# Rezoning Transportation Analysis

Petition Number: 2024-024

Date	Description
3-27-24	First Review (TM)

RZ-1.0

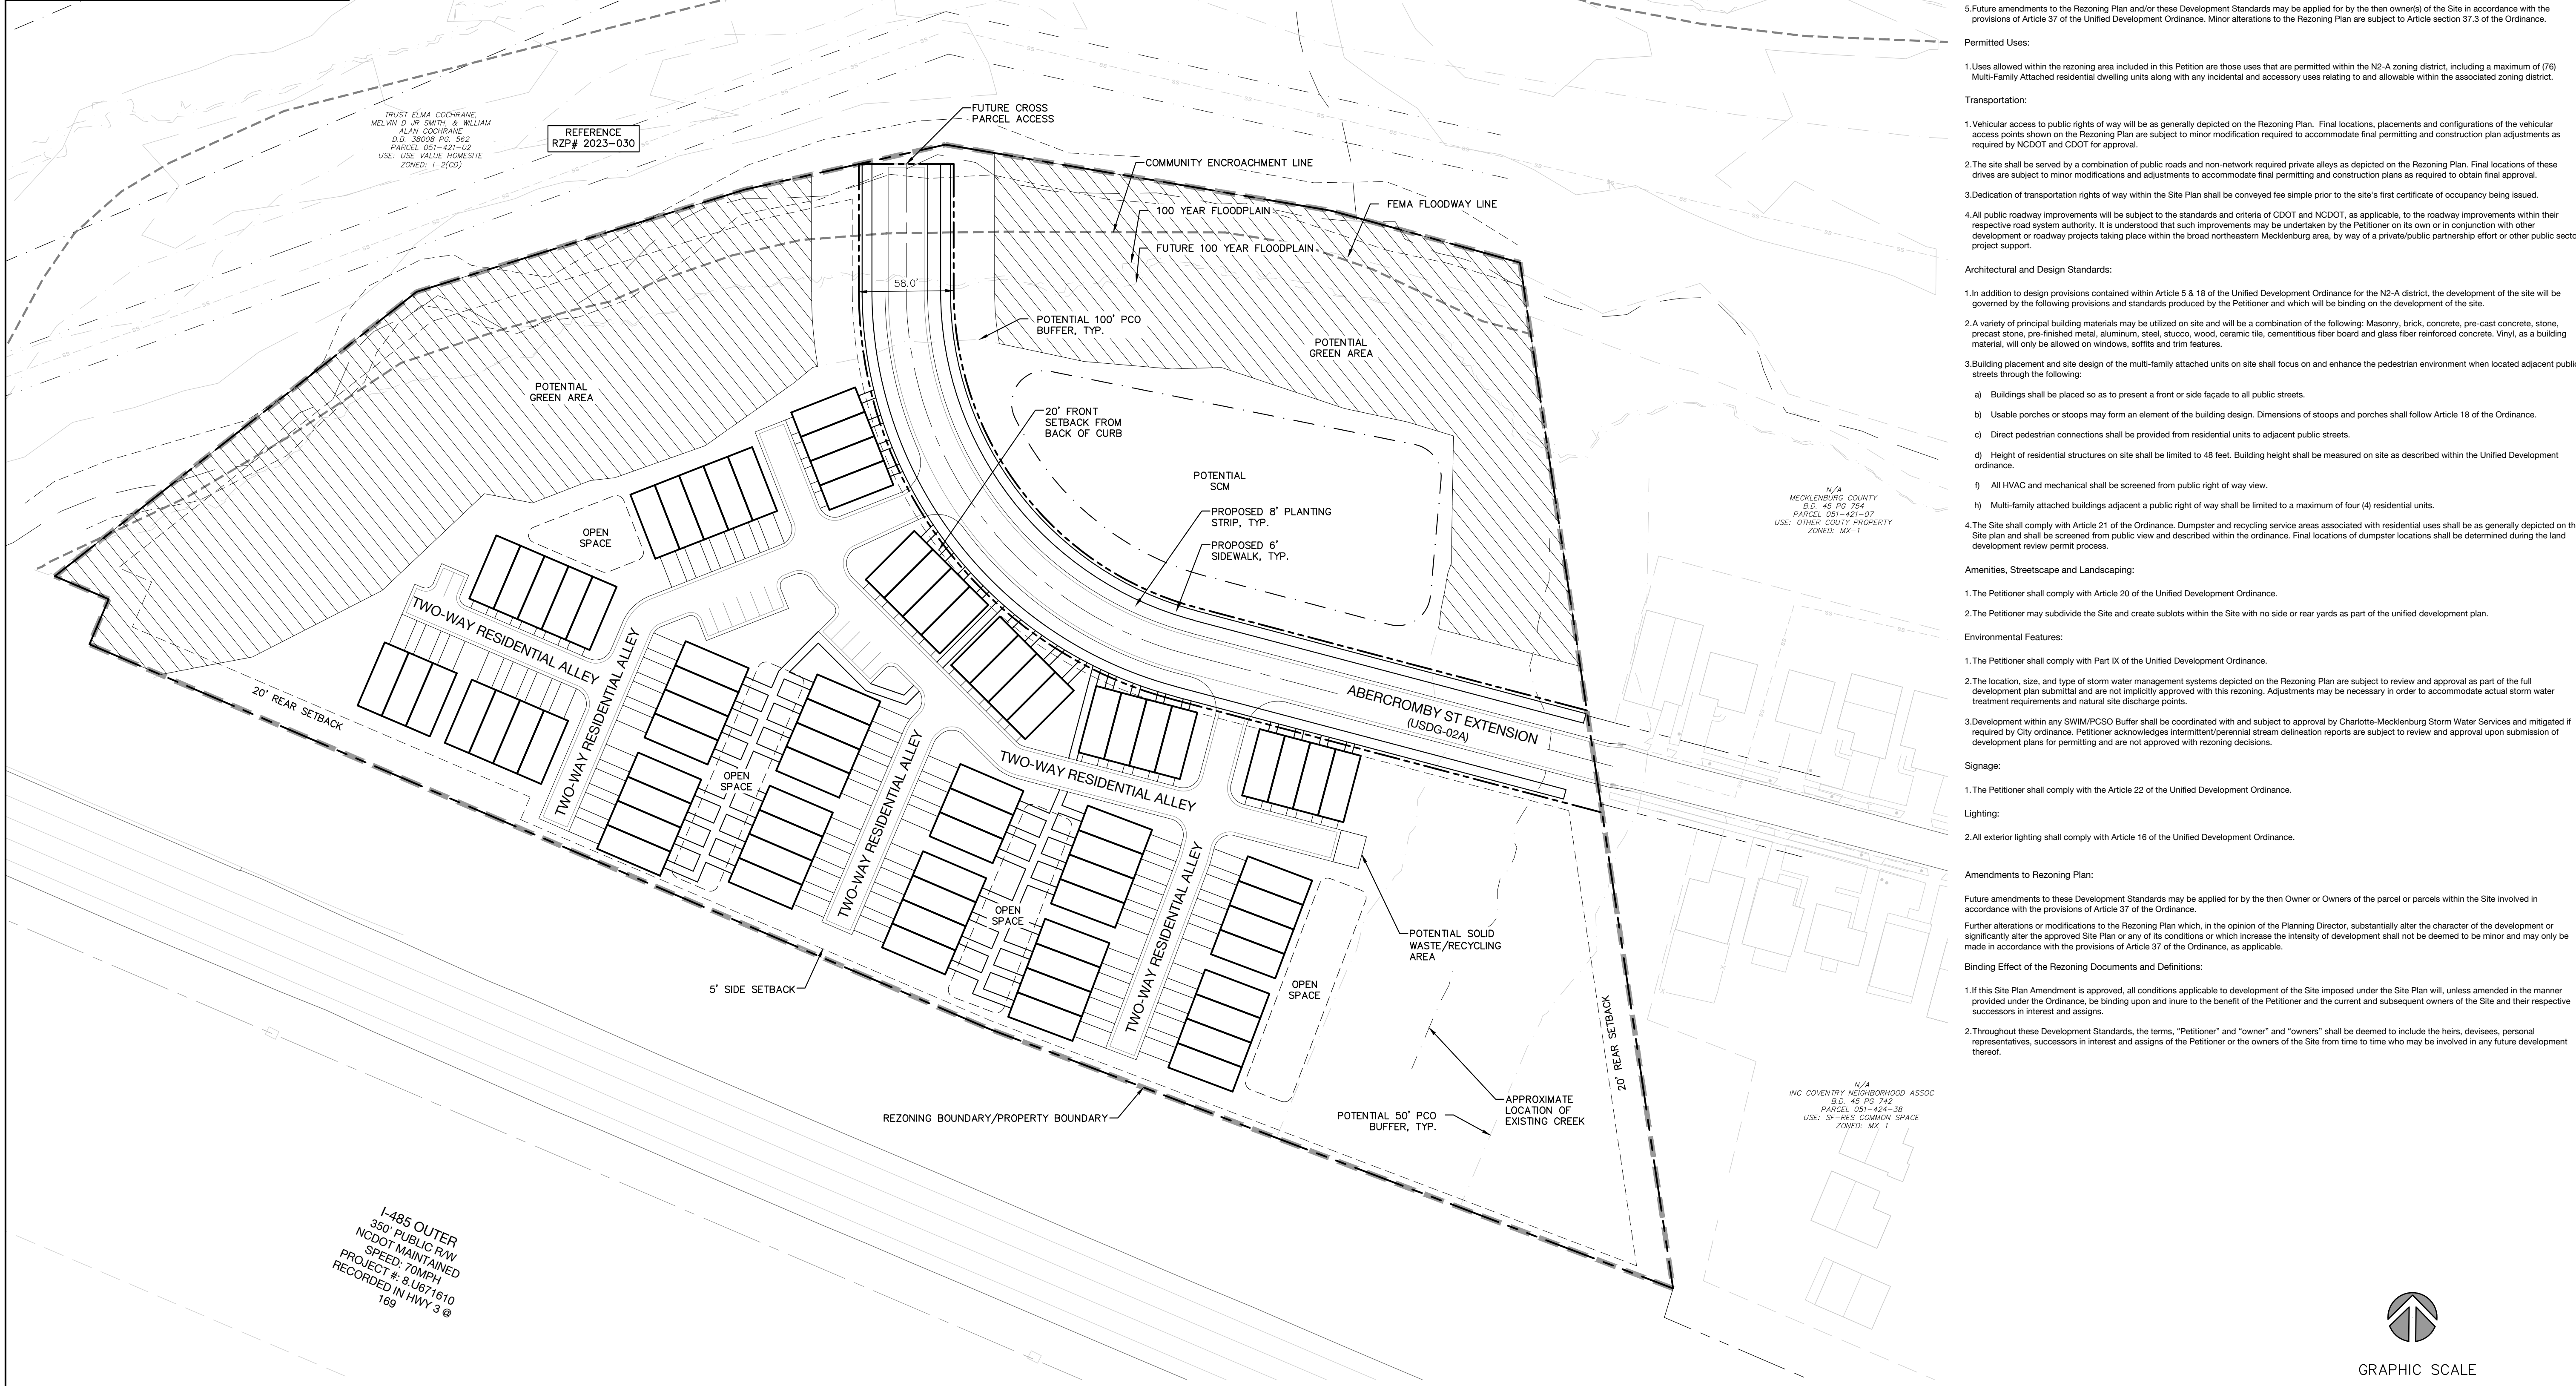
- a. **Abercromby Street:** Location of future back of curb and gutter is to be located at 15 feet from roadway centerline per CLDSM U-02B.

Label and dimension the curb and gutter from the centerline for each road on the site plan.

3. Revise site plan and conditional note(s) to commit to dedicate 29 feet of right-of-way from the road centerline. The site plan shall label and dimension the right-of-way from the road centerline.
4. Revise site plan and conditional notes to commit to connecting Abercromby Street stub to adjacent development in coordination with CDOT and NCDOT.

5. N-2 requires that the roadway be constructed to a residential wide roadway cross section (CLDSM U-03) Per UDO. To remain consistent, CDOT request that this roadway remains as proposed, a residential medium (CLDSM U-02) matching the cross section of approved rezoning 2023-030 and that additional onsite parking stalls are added to the southeastern portion of the site in lieu of providing the on street parking that is provided with a U-03 roadway cross section. Revise site plan and conditional notes to commit to installing parking stalls.

8. Revise site plan and conditional note(s) to construct 8-foot planting strips and 8-foot sidewalks Road and Abercromby Street extension. The site plan shall label and dimension both items from the back of curb and gutter or edge of pavement. Add conditional note The entire facility must be outside of the right of way and within a public access easement. Add conditional note committing to construction and maintenance of the 8-foot sidewalks/multi-use paths on Abercromby Street extension.
